**Consultation Response from KC,
Highways Development Management****2025/93540 adj, Clough Hey, Manchester Road, Marsden, Huddersfield, HD7 6DW****Erection of 1 pair of semi-detached dwellings (within a Conservation Area)****Date Responded: 11/02/2026****Responding Officer: D. Stainsby****Responding Ref: K1-8/50****RECOMMENDATION:**

Client	SB HOMES
Project	CLOUGH HEY, MARSDEN
Detail	TRACKING ANALYSIS
Drawn	HH
Checked	HH
Date	DEC-24
Scale	1:200@A1 E24/6256/001
Dwg. No.

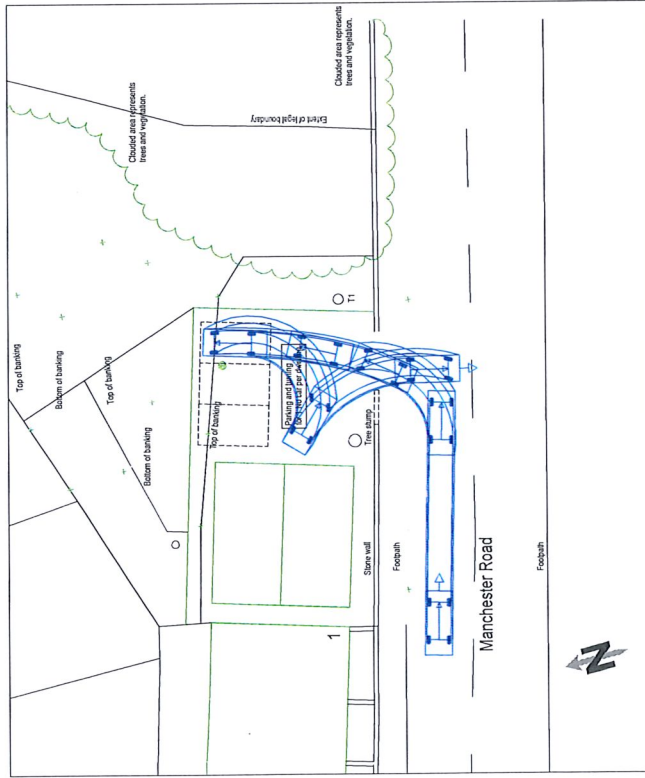
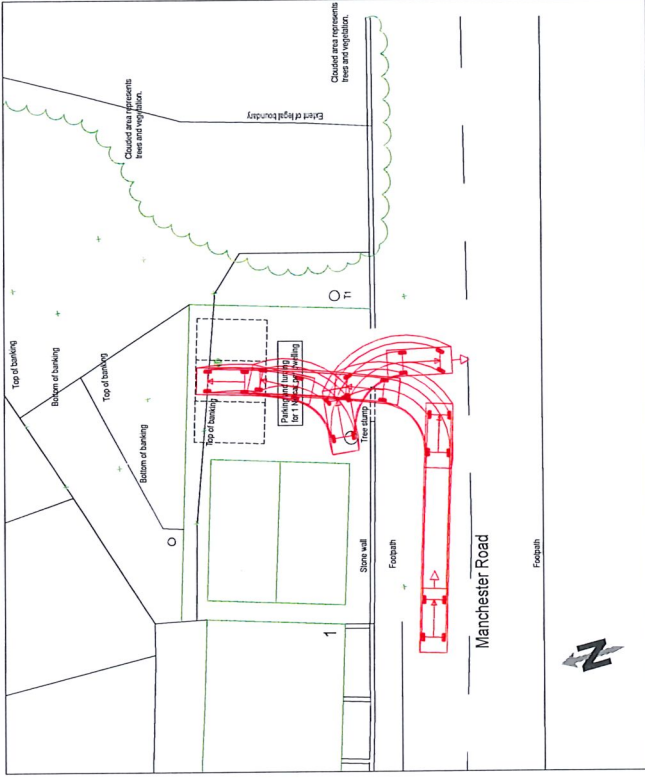
Parking for 3 cars have been proposed, together with internal turning. This falls short of the recommended minimum parking requirements.

In total, therefore a minimum of 5 car parking spaces is required. (2 per dwelling and 1 visitor space) together with internal turning.

Unfortunately, the size of the proposed site is too small to achieve this and, as such, cannot be supported by Highways D.M.

Site plan (1:200)

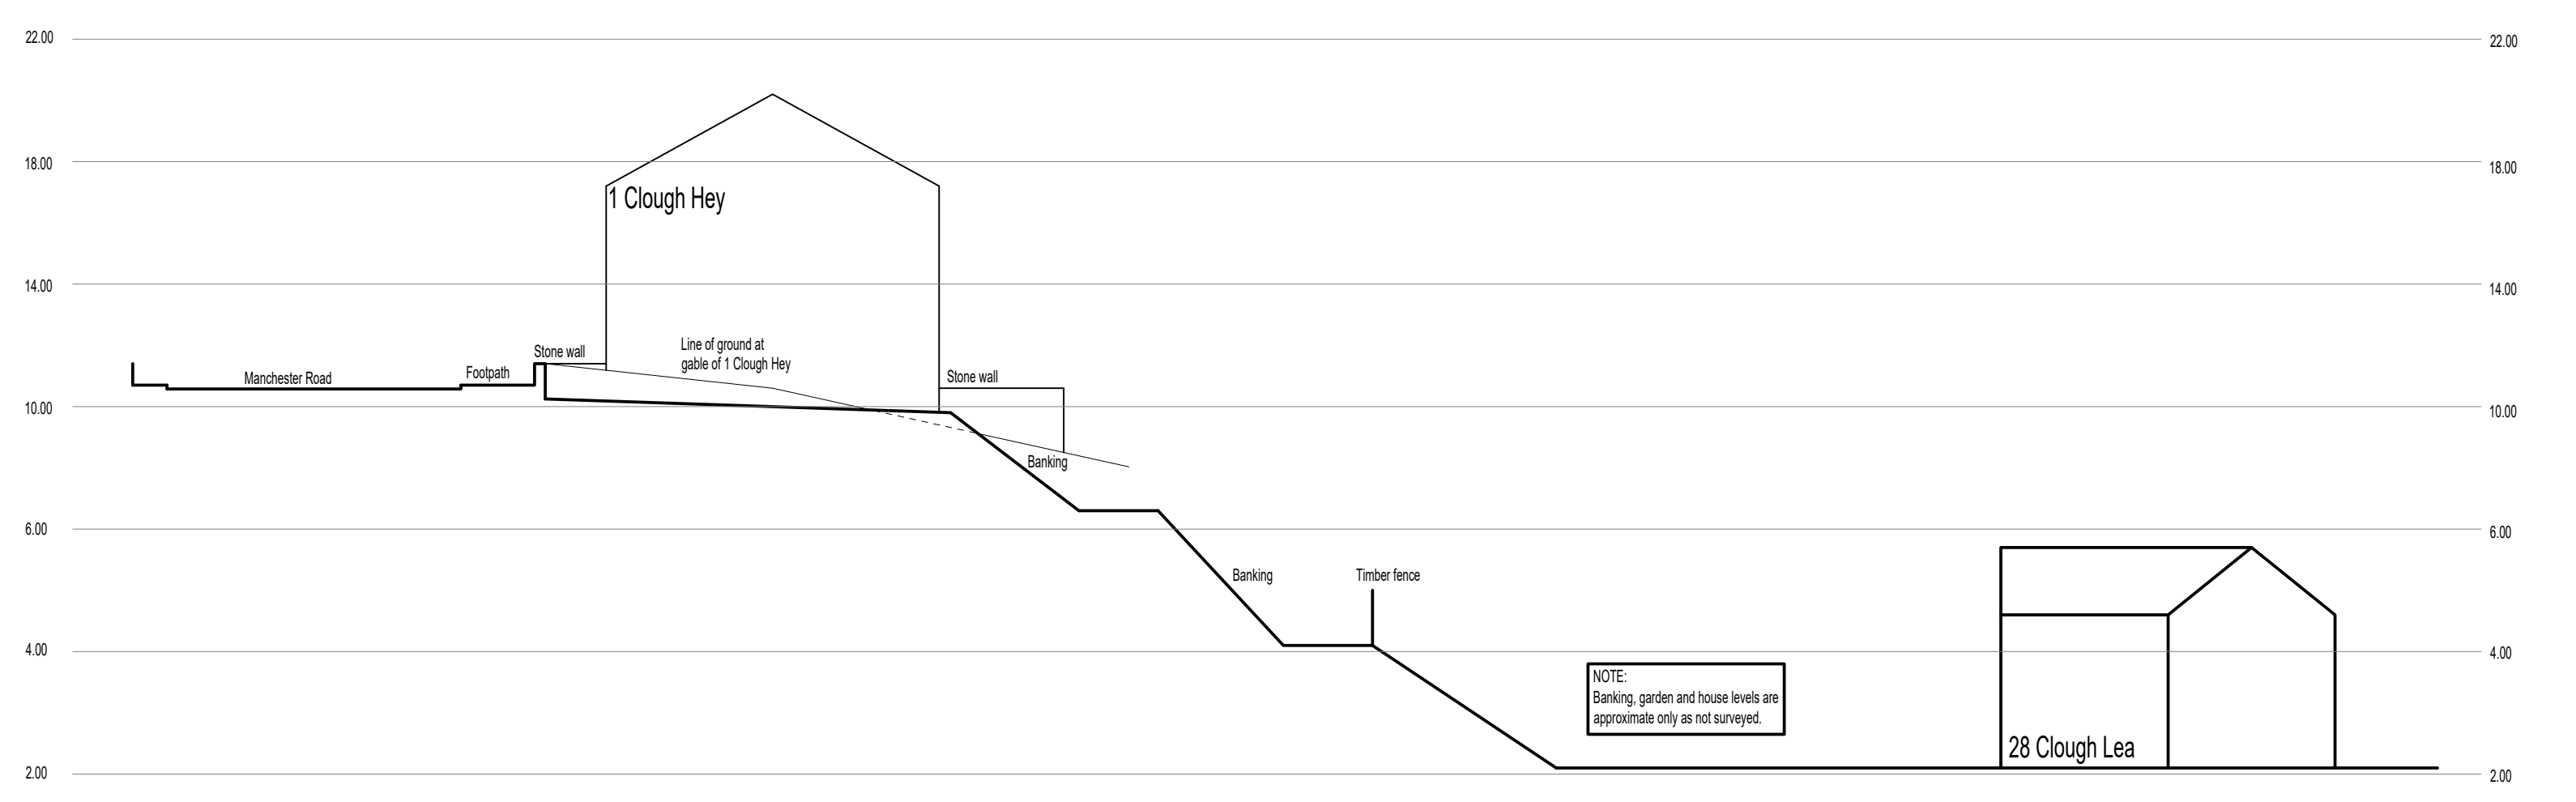
For a 30mph speed limit sight lines of 2.4m x 43m should be achievable and demonstrated on a suitable plan, any shortfall of this requirement should be in accordance with 85%ile wet weather speed readings (if below 30 mph).

A revised layout showing the required visibility splays can be met should be provided to ensure that the minimum visibility can be provided for vehicles leaving the site onto A62 Manchester Road.

2 car parking spaces per 3 bedroomed dwelling should be provided.

No bin store and/or bin collection/presentation is shown on the proposed plans.

A bin collection/presentation point should be located adjacent to the public highway and must not obstruct the adopted highway or the driveway.

Details of the waste collection for the proposed dwelling should be provided, with the location of a waste collection presentation point being clearly marked on a drawing in such a location that is easily accessible to the collection team and where it will not obstruct the access or the adopted highway for road safety reasons.
